Appeal Decision

Appeal Ref: APP/A2525/W/17/3184614

215 Bridge Road, Sutton Road, Spalding PE12 9SL

- The appeal is made under section 78 of the Town and Country Planning Act 1990 against a refusal to grant planning permission.
 - The appeal is made by Mr Andrew Lilley against the decision of South Holland District Council.
 - The application Ref H18-0358-17, dated 12 April 2017, was refused by notice dated 4 July 2017.
 - The development proposed is pair of semi-detached houses and one detached house.
-

PROPOSED BLOCK PLAN

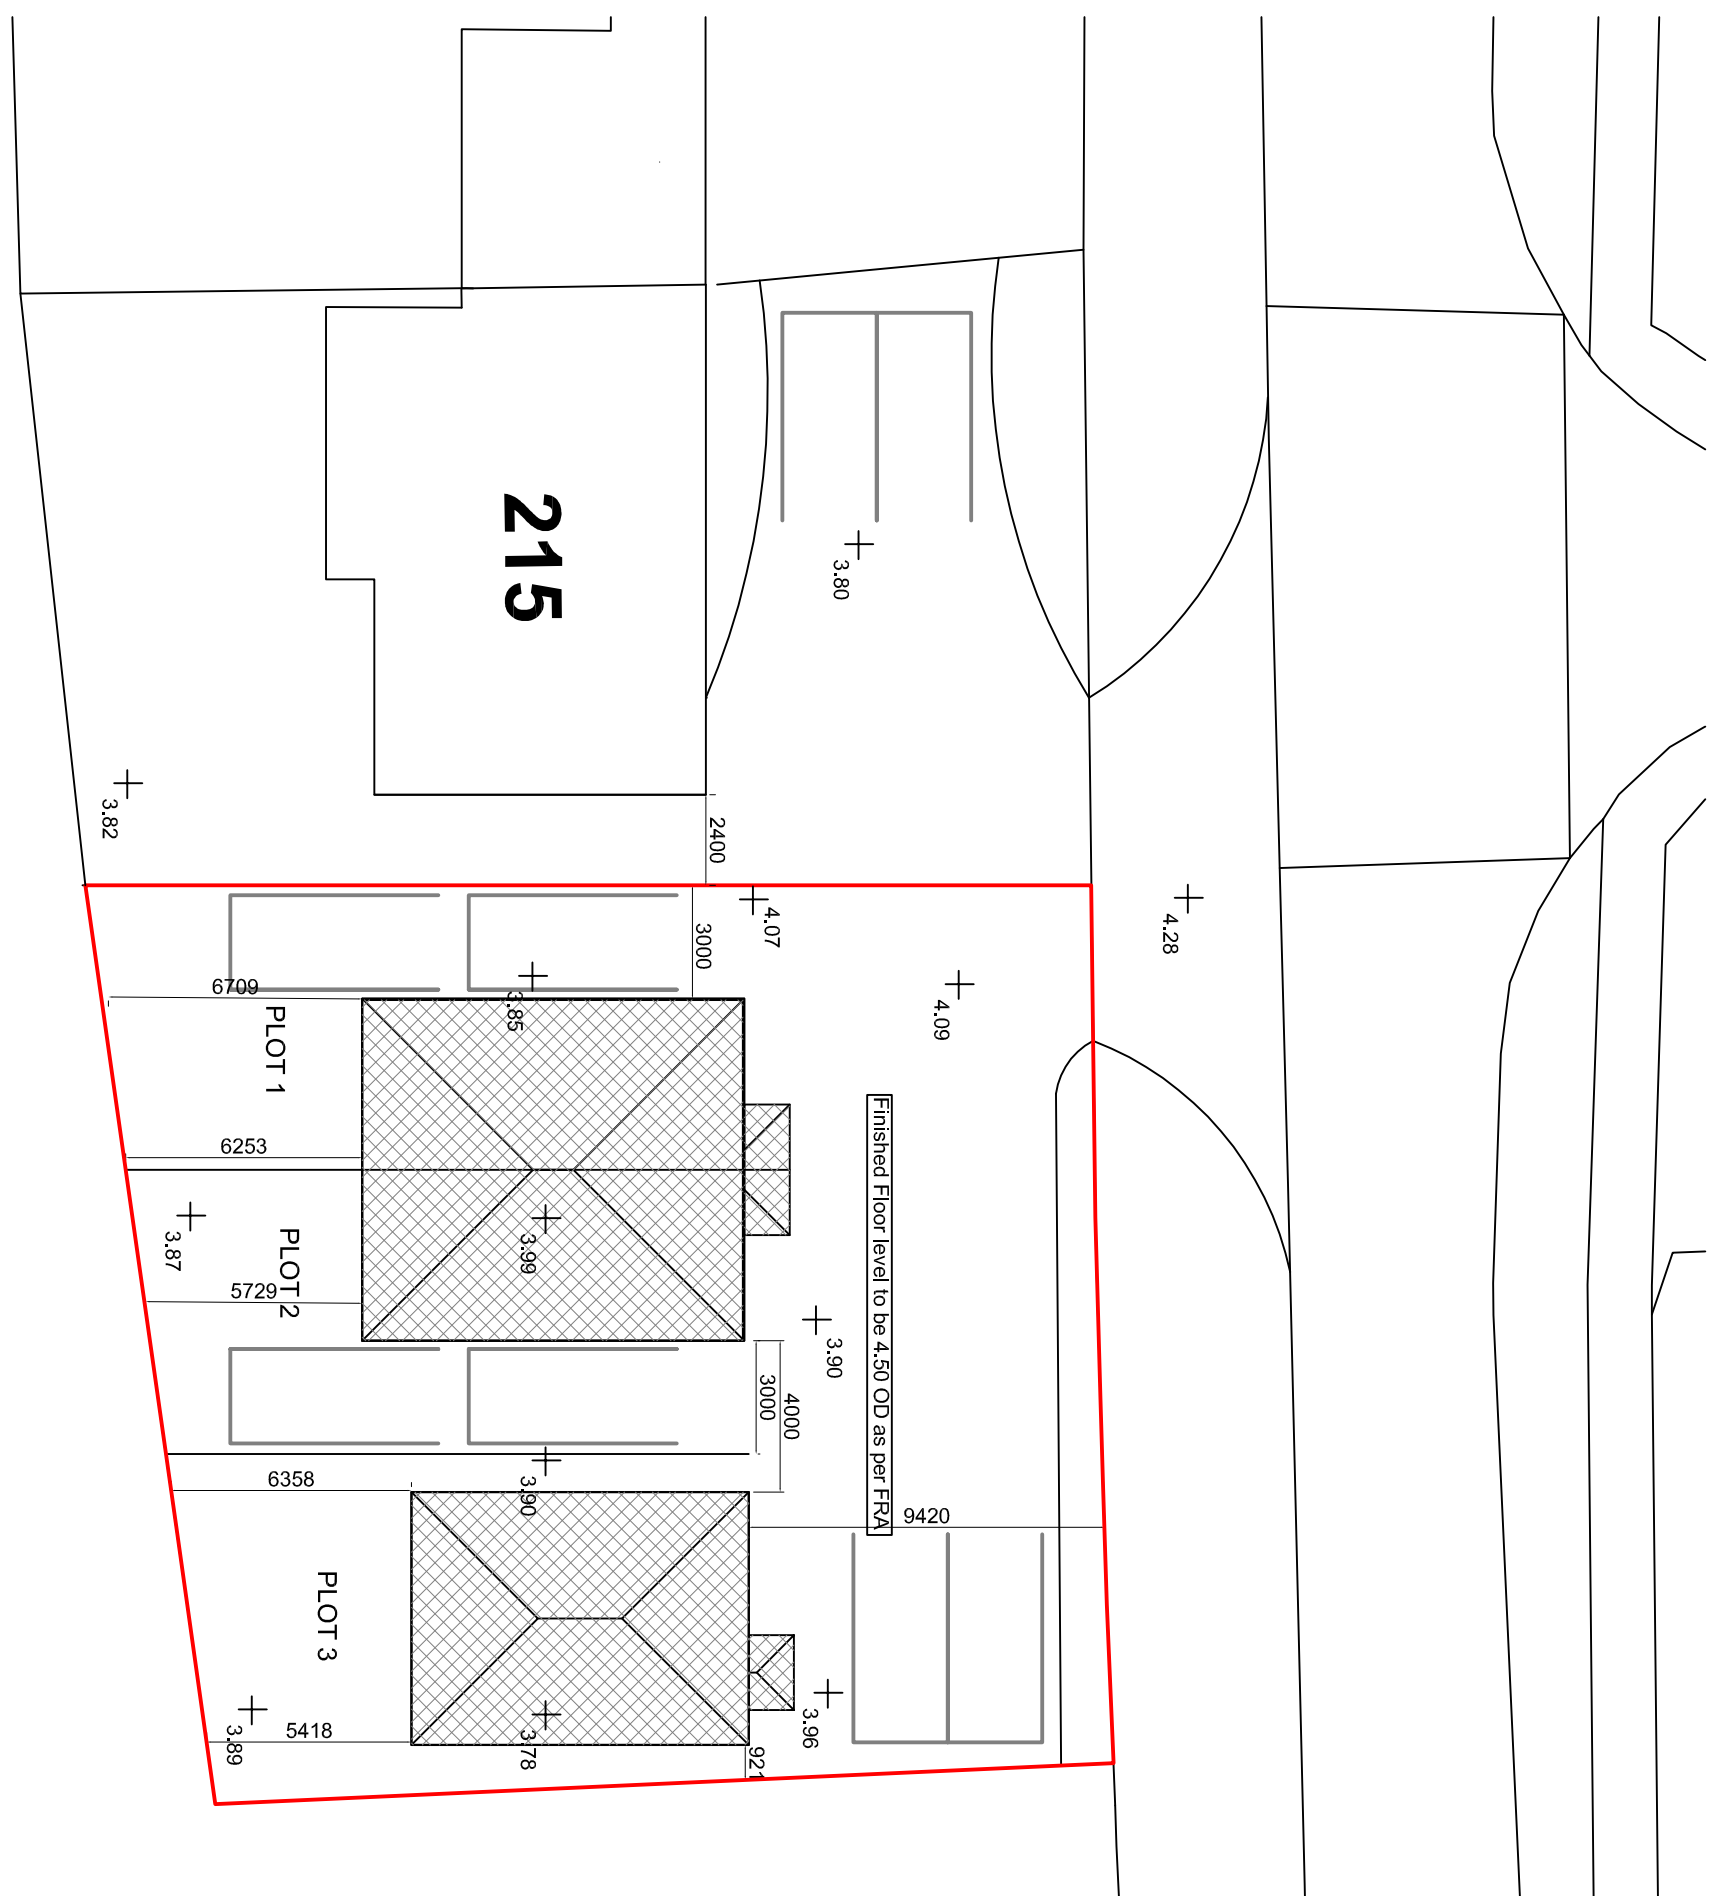
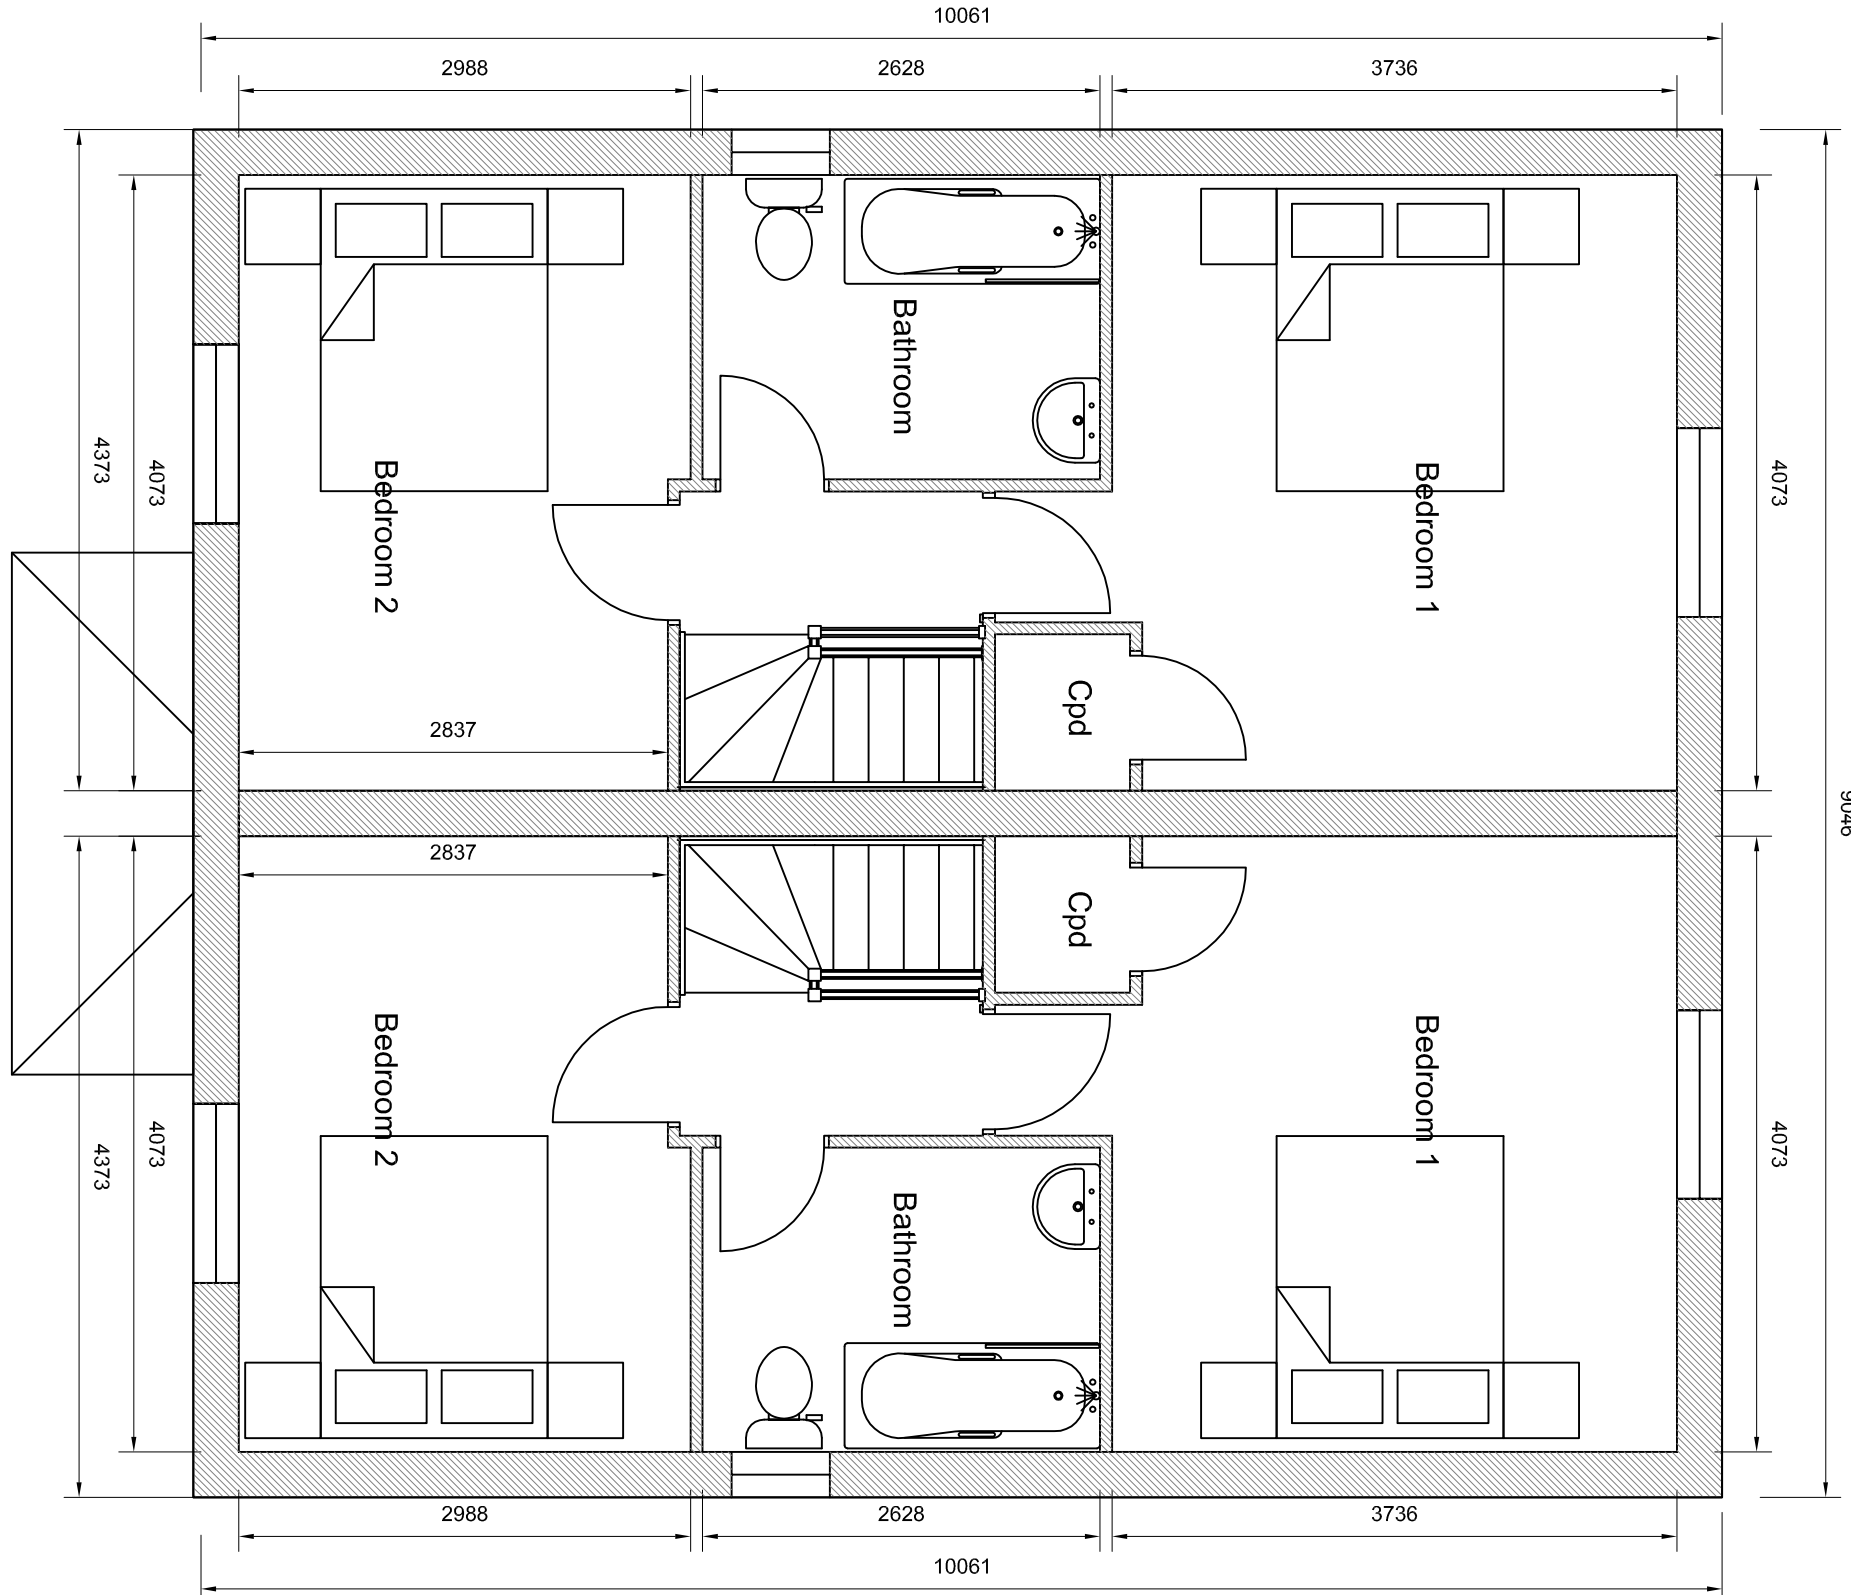
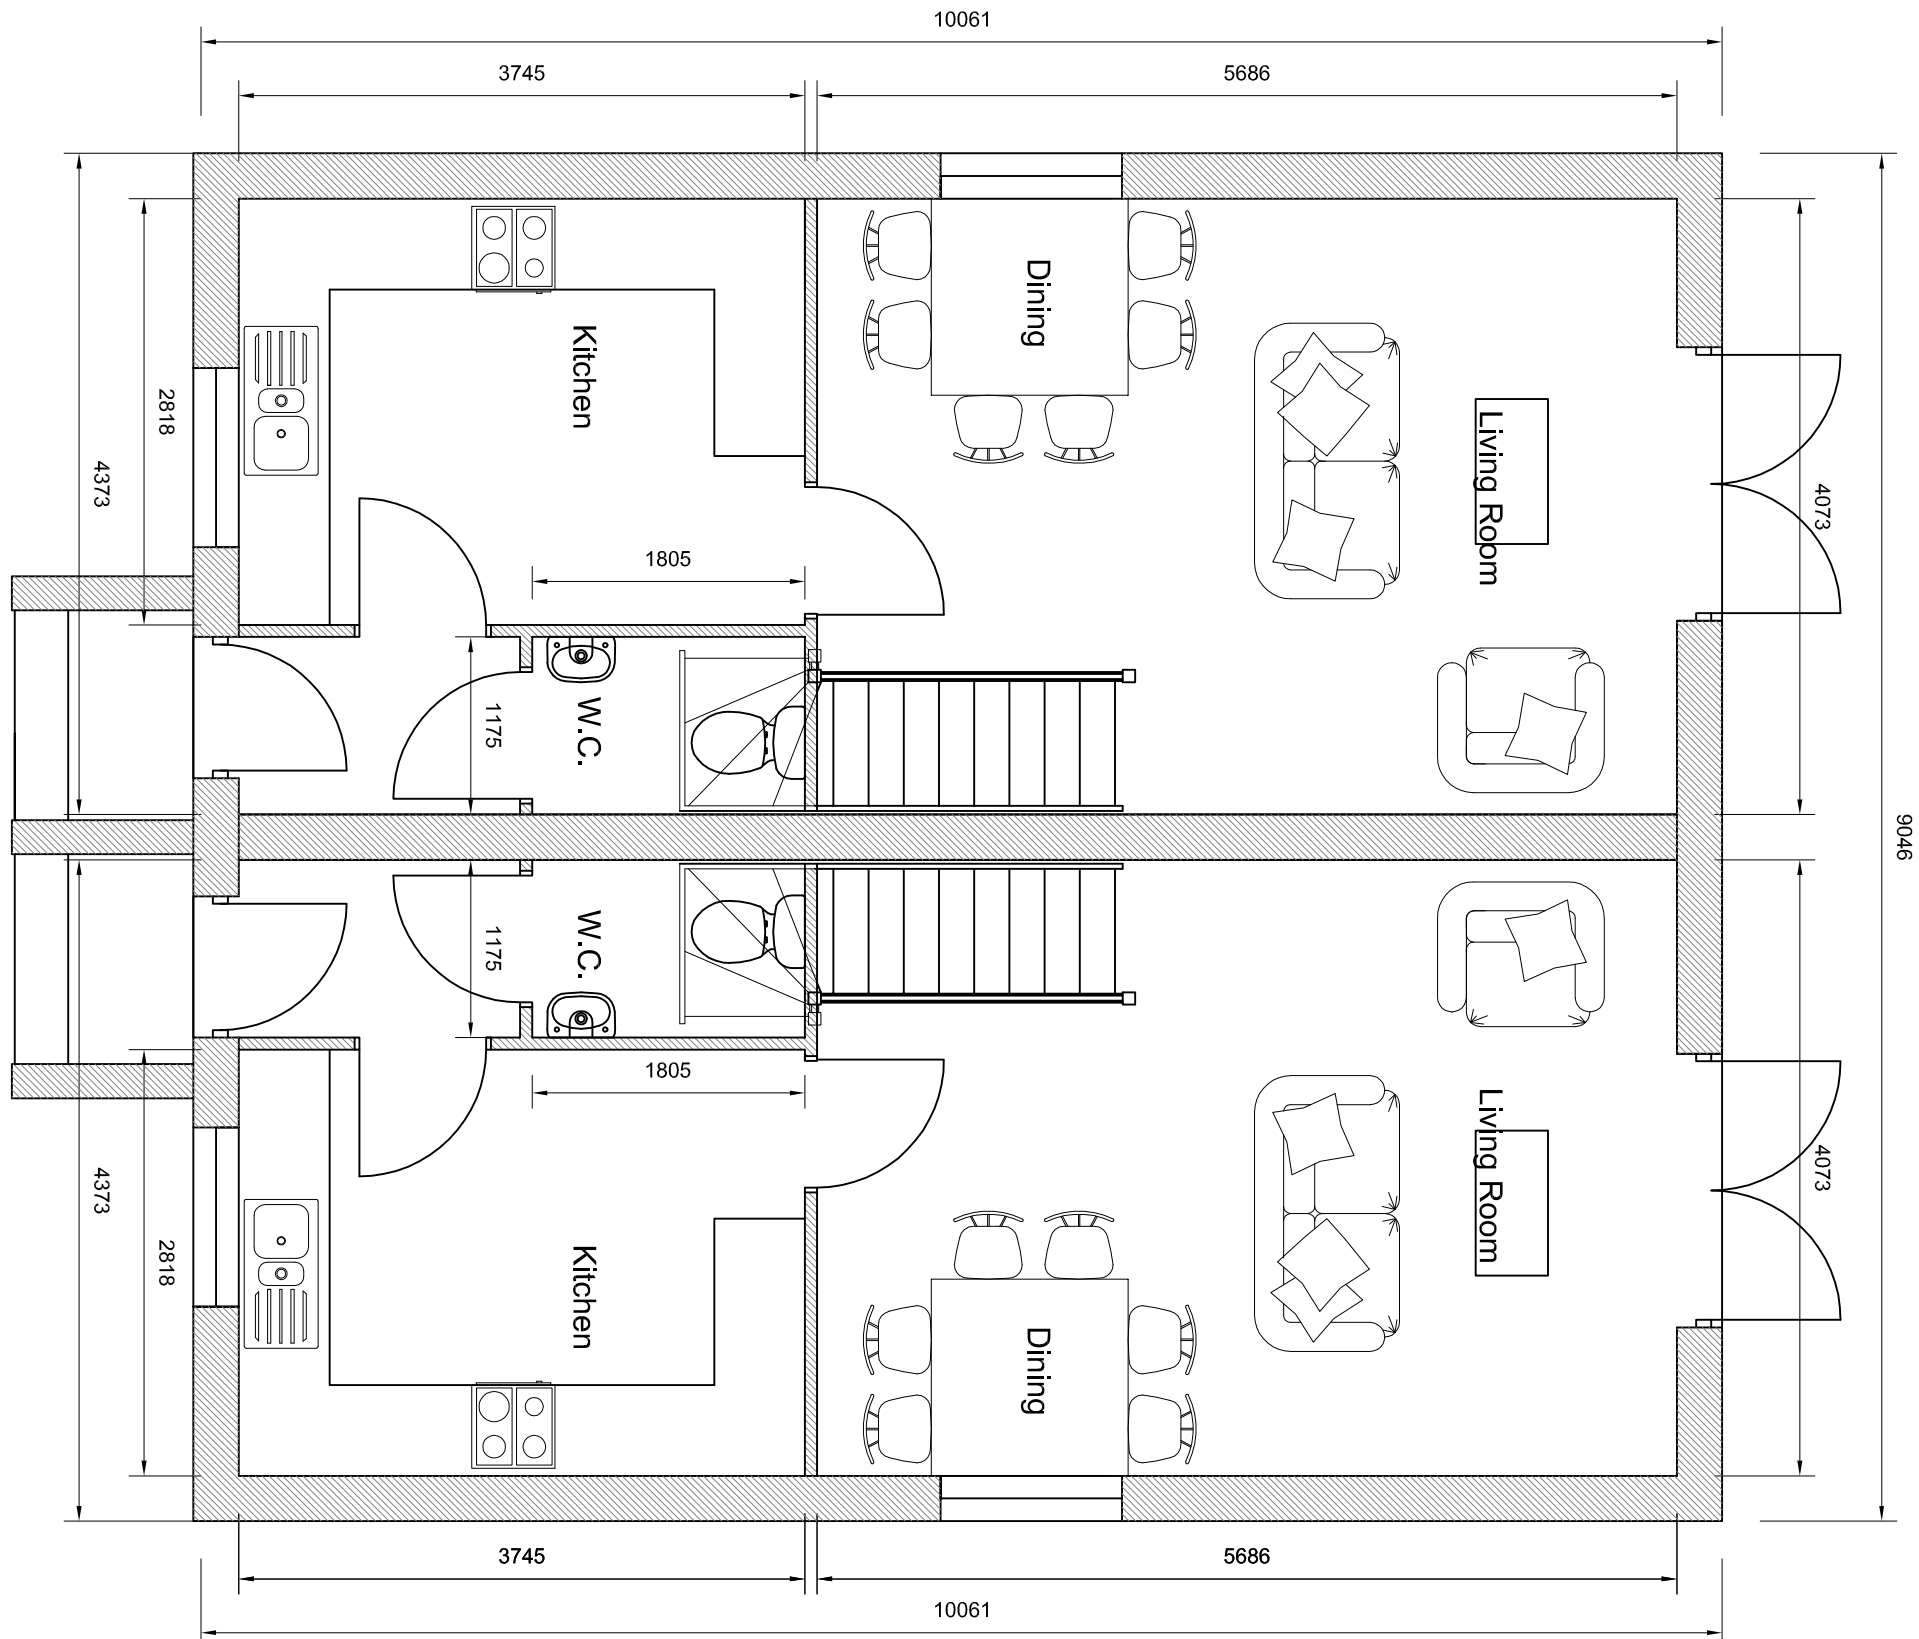
3. The appeal site is open land adjacent to 215 Bridge Road (No 215), which is a semi-detached dwelling fronting Bridge Road.
4. The development would comprise a pair of semi-detached (Plots 1 and 2) and one detached dwellings (Plot 3). The semi-detached dwellings would have two end to end parking bays beside their flank walls. There would be no turning space for these vehicles other than in front of those semi-detached dwellings. The detached dwelling would have two side by side parking bays located forward of its front elevation, whose turning space would also be in front of the semi-detached dwellings.

9. The appellant argues that the development would be similar to the development next to No 217 but those dwellings appear to be on significantly larger plots. This observation is confirmed by the Council's comparison of the relative plot sizes of the two developments³. I conclude that the development would appear cramped as the parking bays and turning space would take up a disproportionate area of the site and would appear to dominate the frontage. In the absence of other concerns this would not necessarily be sufficient to warrant dismissal of the appeal, but my conclusions in this regard reinforce my reasoning in relation to the living conditions of future occupiers, as outlined above.

10. Consequently, the development would be contrary to the design aims of LP Policy SG14 of the Local Plan and in particular section (9) which states that the layout of vehicular access, parking and manoeuvring will be taken into consideration when assessing the design and layout of such development. It would also be contrary to the design aims of the National Planning Policy Framework (the Framework) which seeks to secure high quality design.
